STERLING RANCH FILING 5 PUD PRELIMINARY PLAN

LETTER OF INTENT

AUGUST 2023

LOT TYPICALS

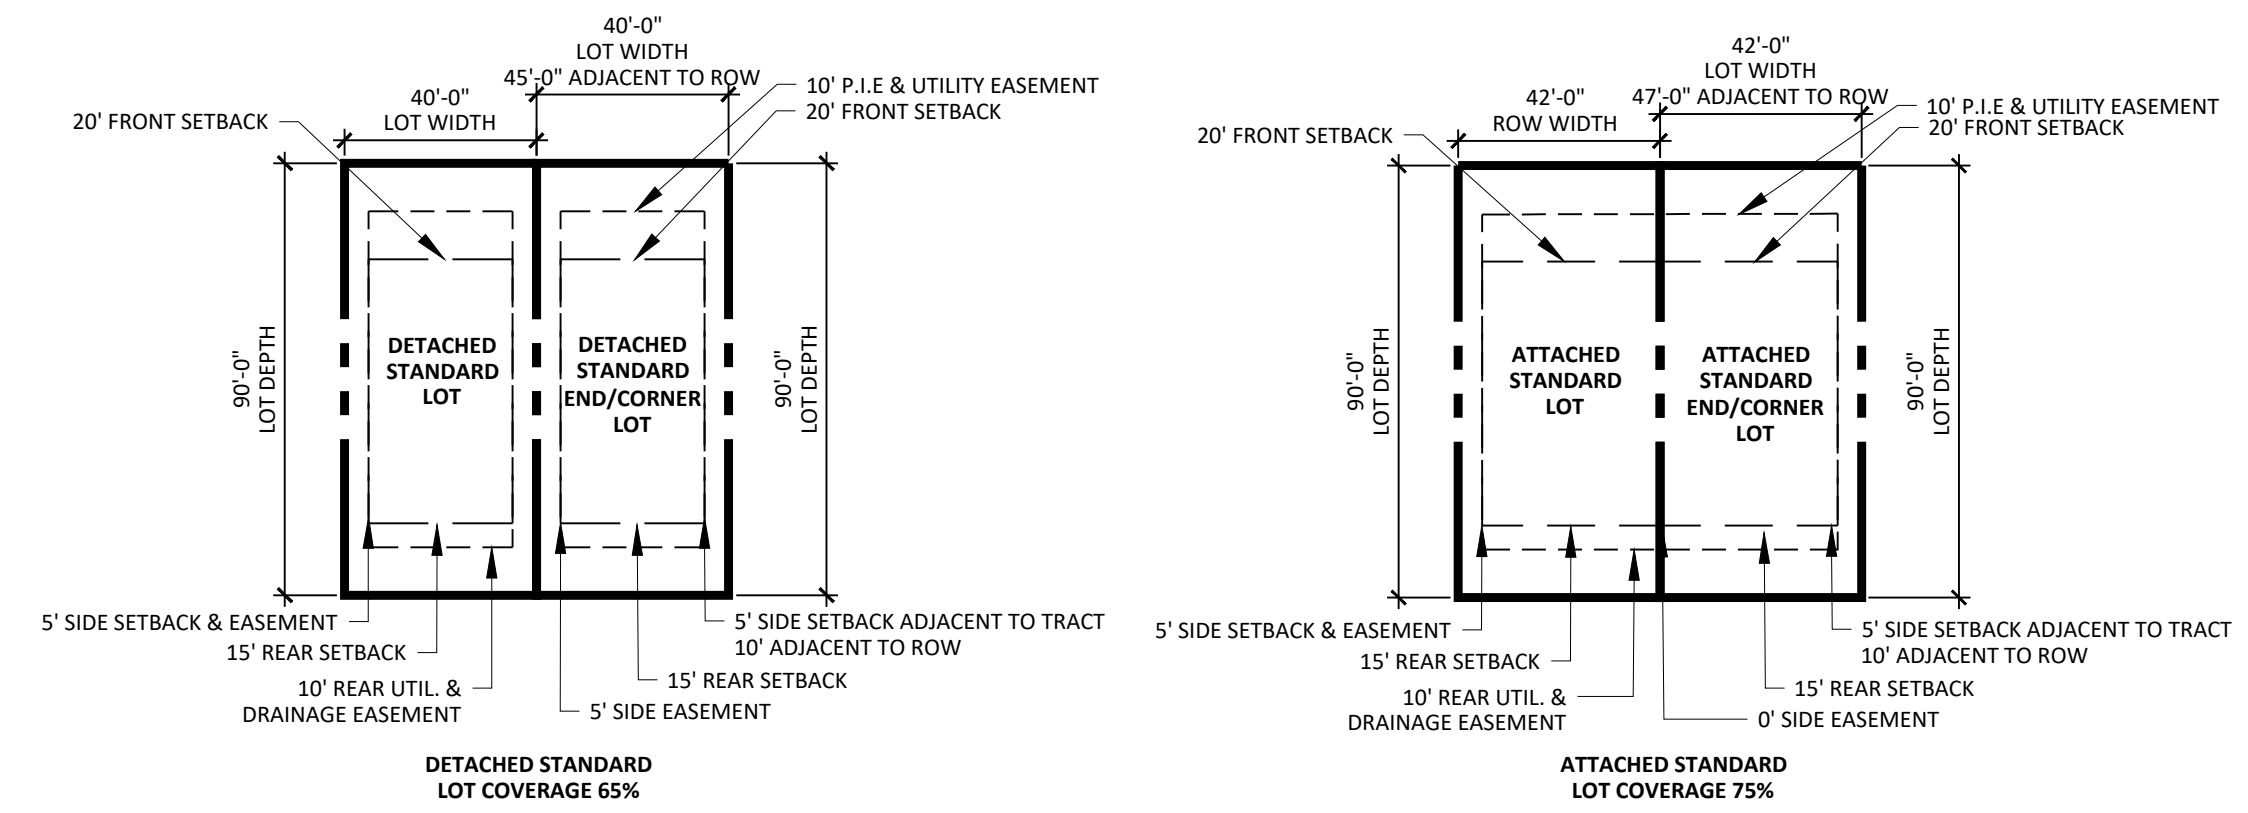
this is really low- approx 1226 SF home footprint including garage...? other PUD small lots our 65%

Acknowledged, section revised.

8 6' CONCRETE SLAT WALL

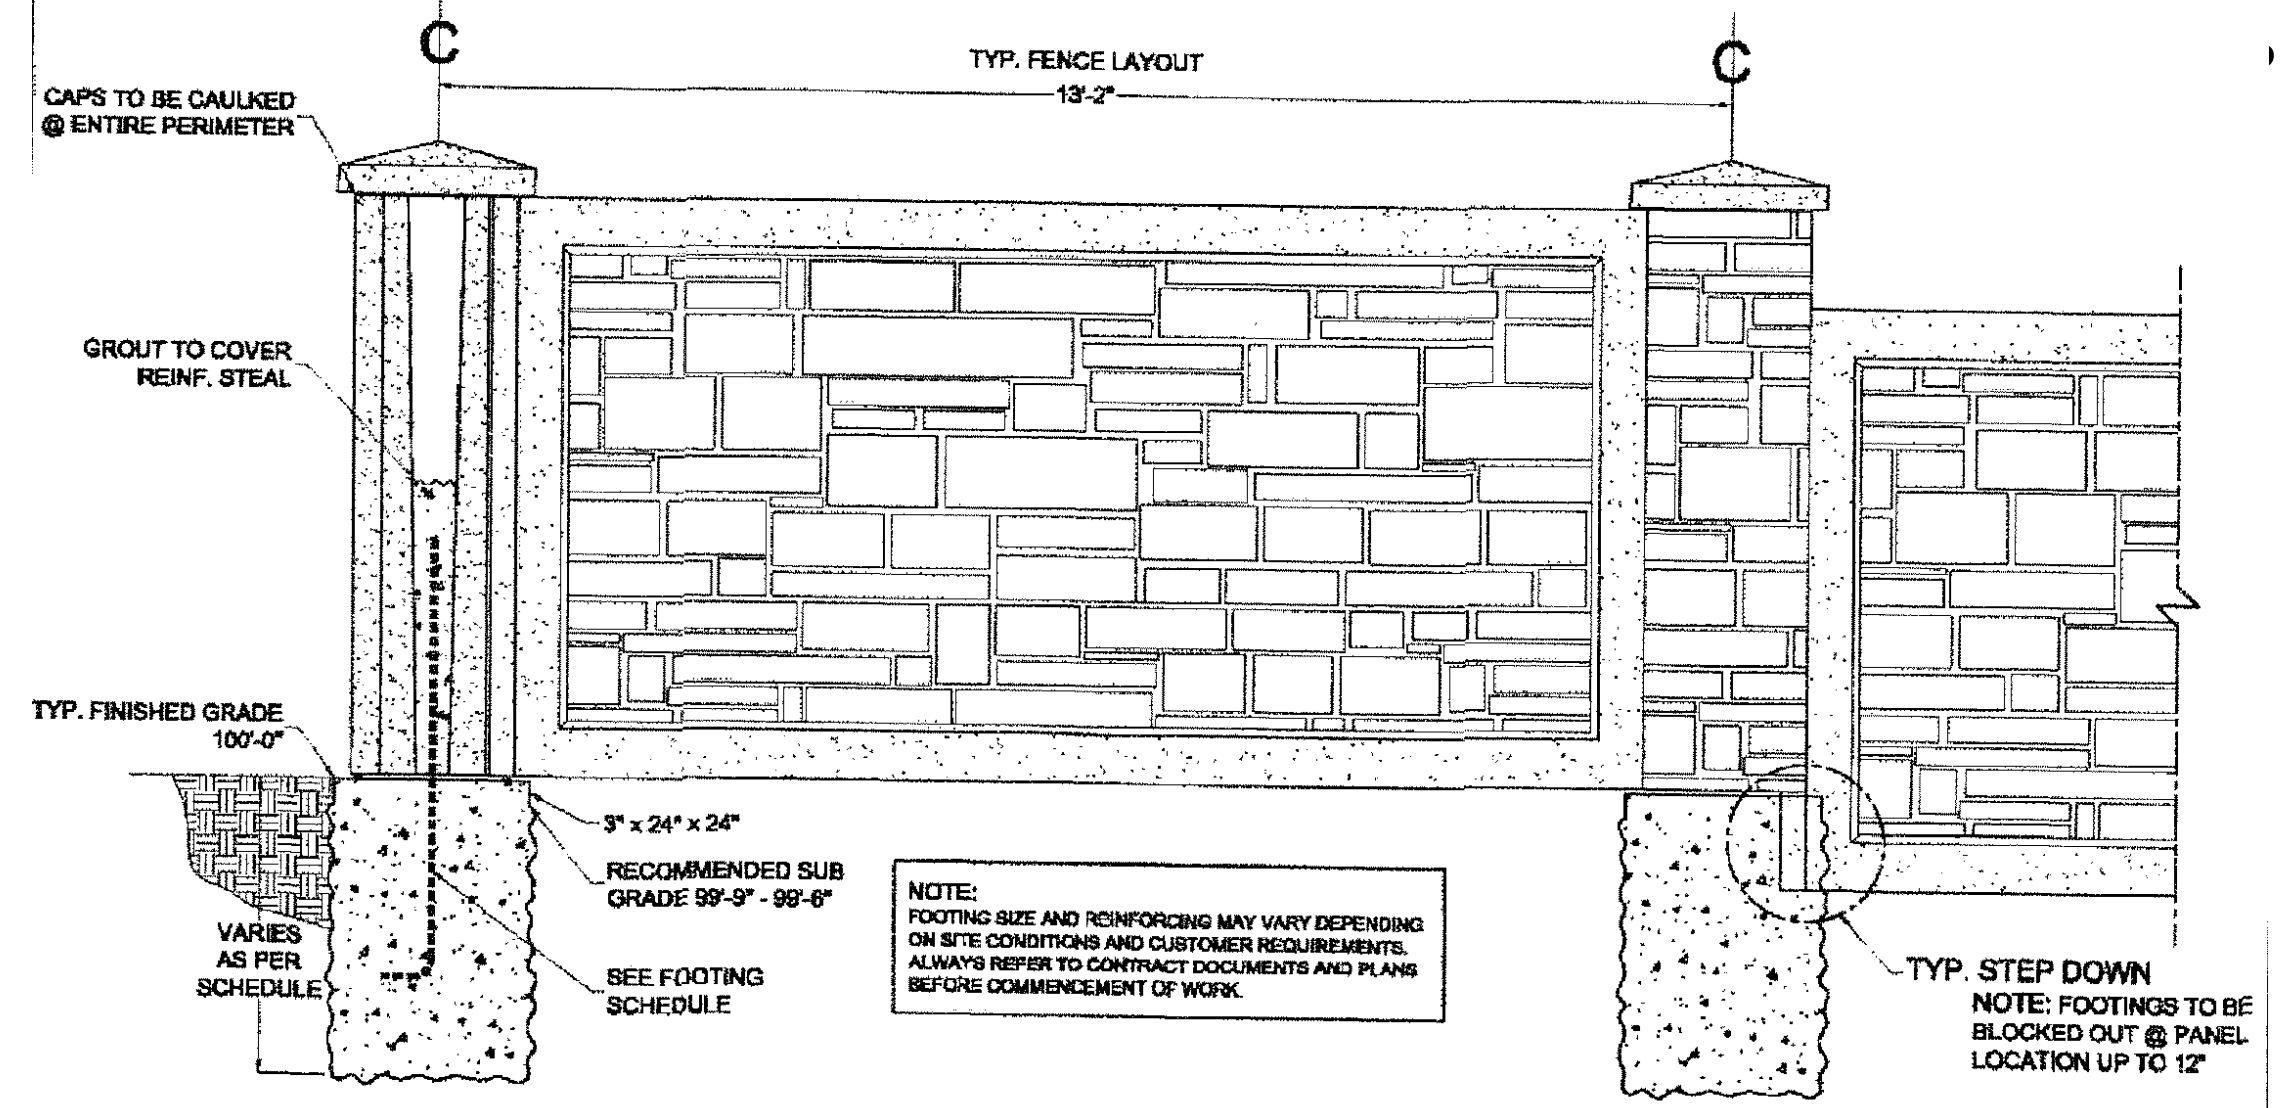
industrial noise- did you want to address w landscape and fencing as added info?

yes, section revised.
